Rezoning Transportation Analysis

Petition Number: #2022-157

General Location Identifier: 02912112

REZONING SITE PLAN

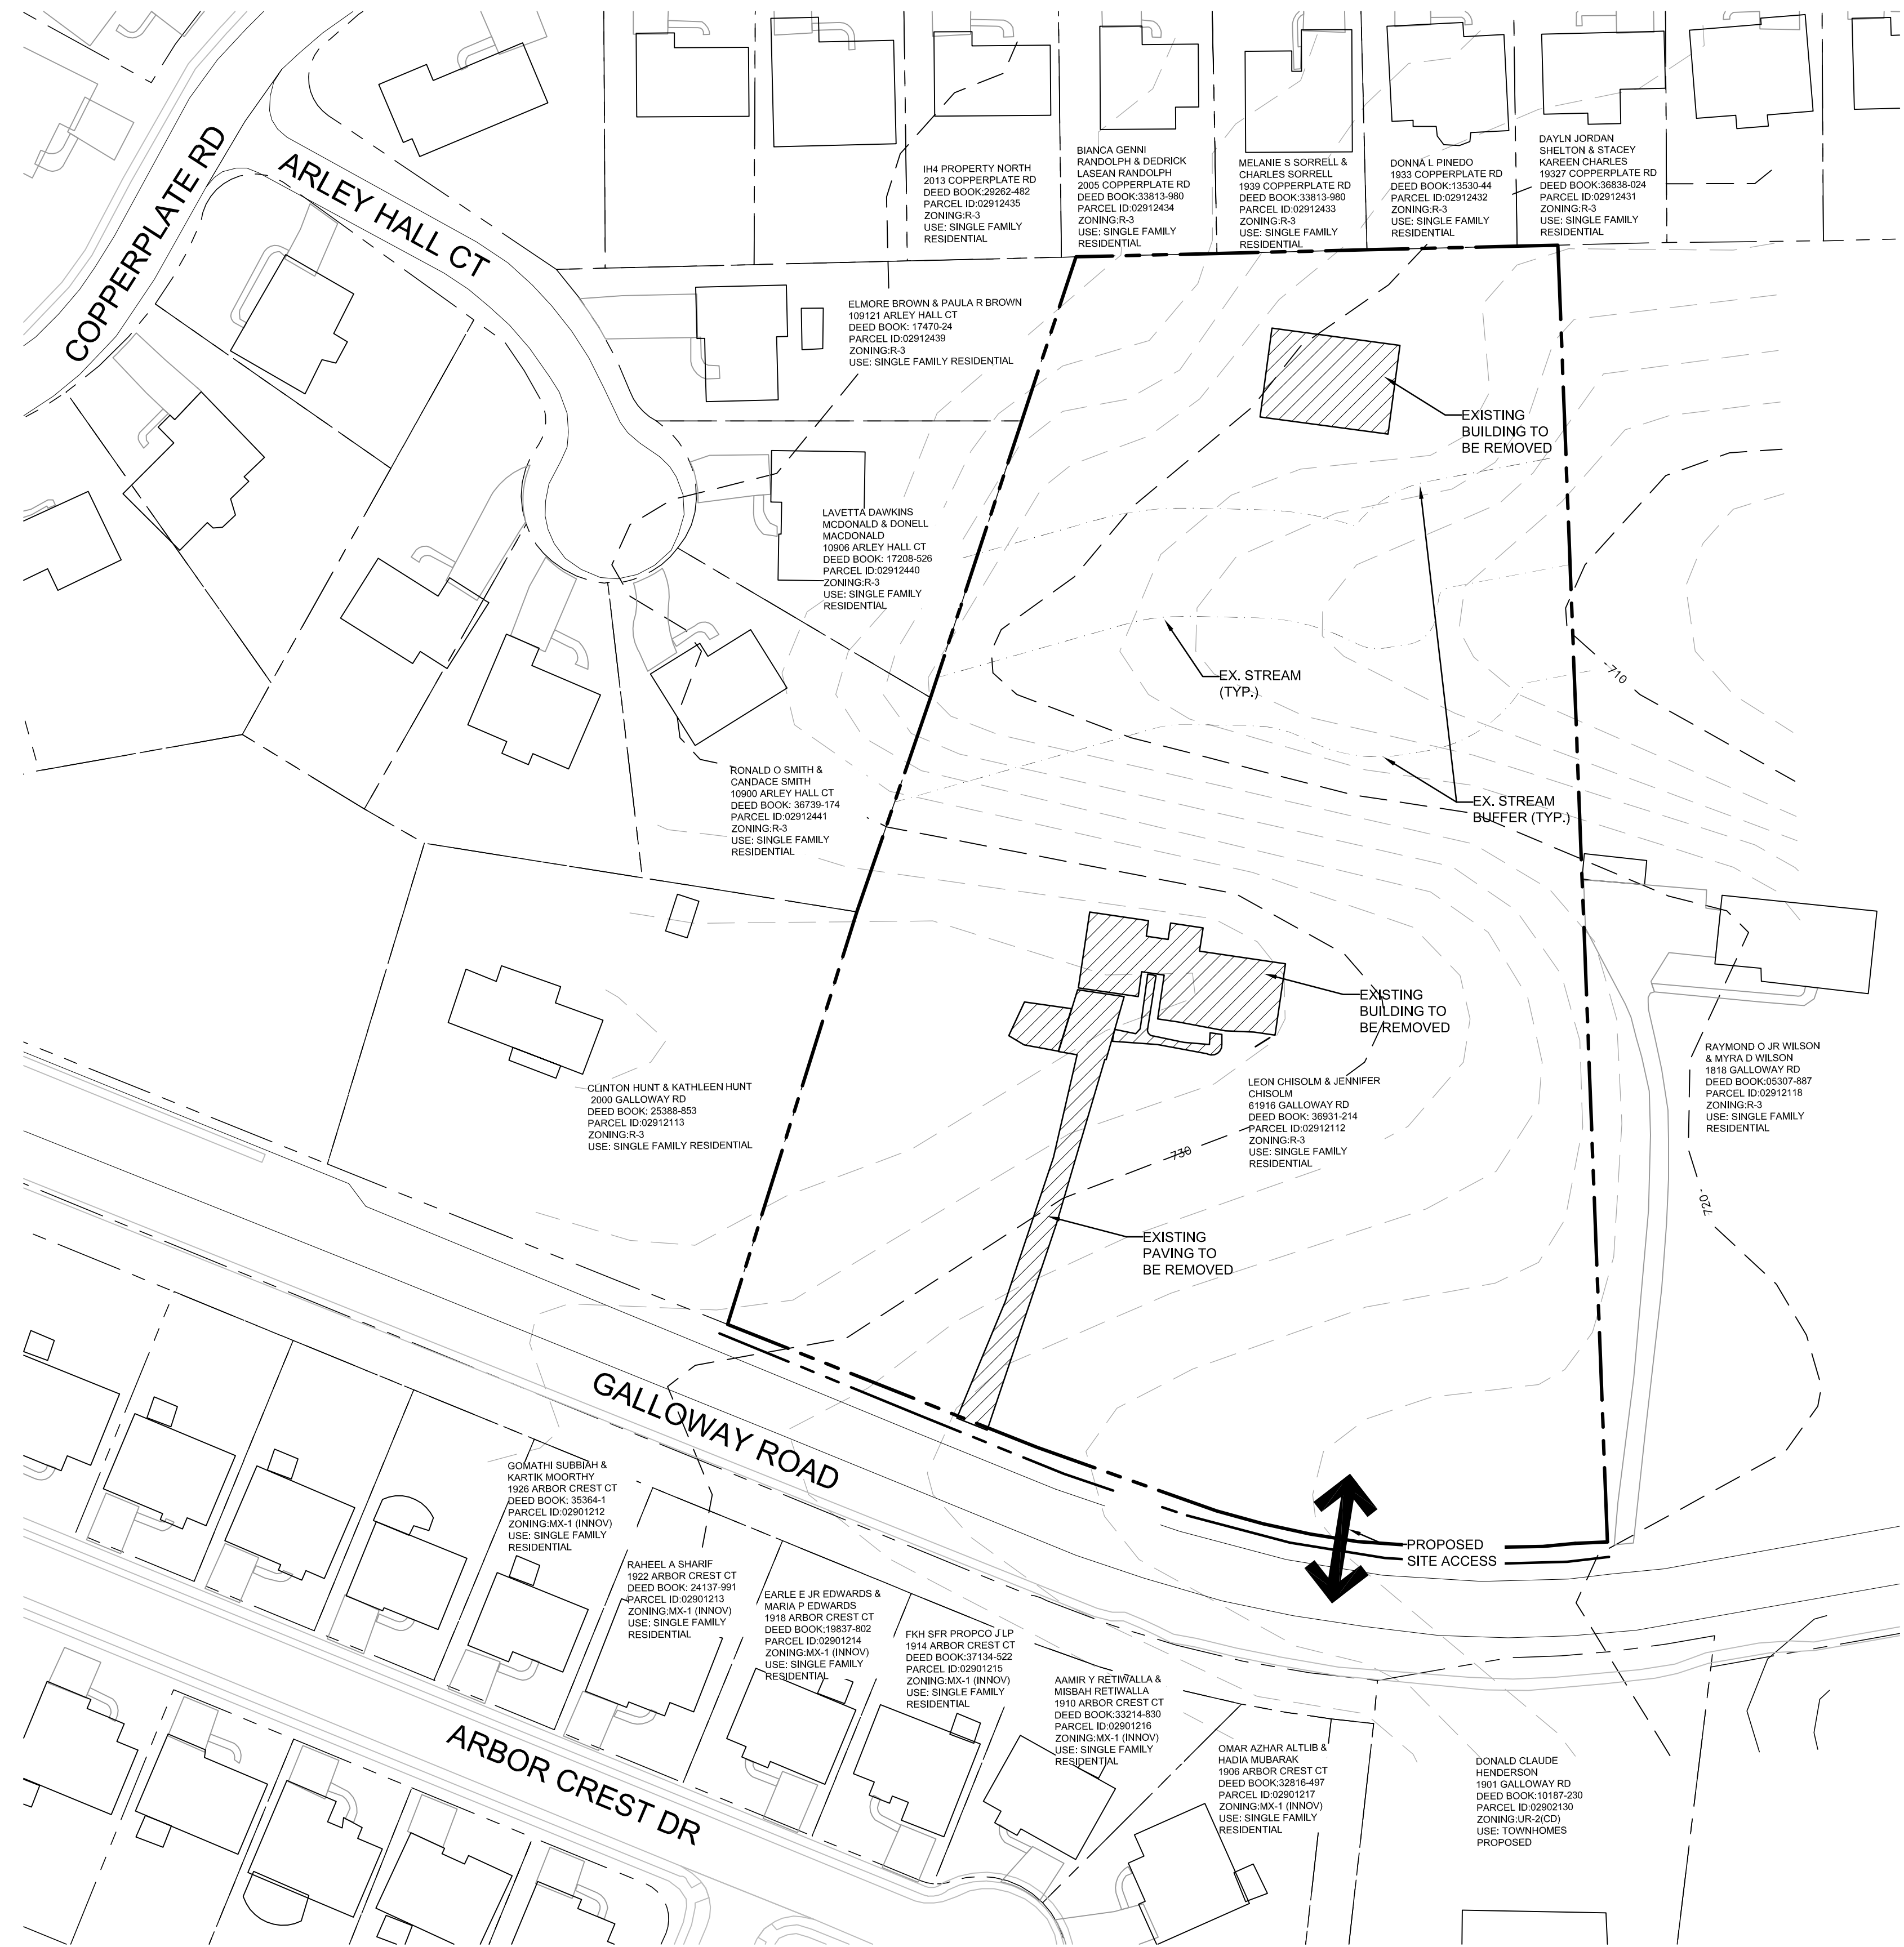
- a. ~~**Galloway Road:** Location of curb and gutter to be moved to 17.5 feet from roadway centerline to accommodate the Charlotte Streets Map with a roadway typical per CLDSM U-07.~~

~~Label and dimension the curb and gutter from the centerline for each road on the site plan.~~

3. ~~Revise site plan and conditional note(s) to commit to dedicate 36 ft right-of-way from the road centerline. The site plan shall label and dimension the right of way from the road centerline.~~

4. ~~**Outstanding Comment From 02-22-23:** Revise site plan and conditional note(s) to commit to providing 75 feet of internal protected stem. Dimensioned from curb return to curb return.~~

~~**Clarifying Comment 04-20-23:** Revise site plan by dimensioned from curb return to curb return.~~

- ~~6. CDOT REQUEST that site plan revisions and conditional note revisions are made to commit to constructing the internal private roadways and alleys to CLDSM standards 11.13 and 11.19 respectively. Site plan shall callout standards on site plan and noted in a conditional note.~~
7. Revise site plan and conditional note(s) to commit to extending private street stubs to the property line.
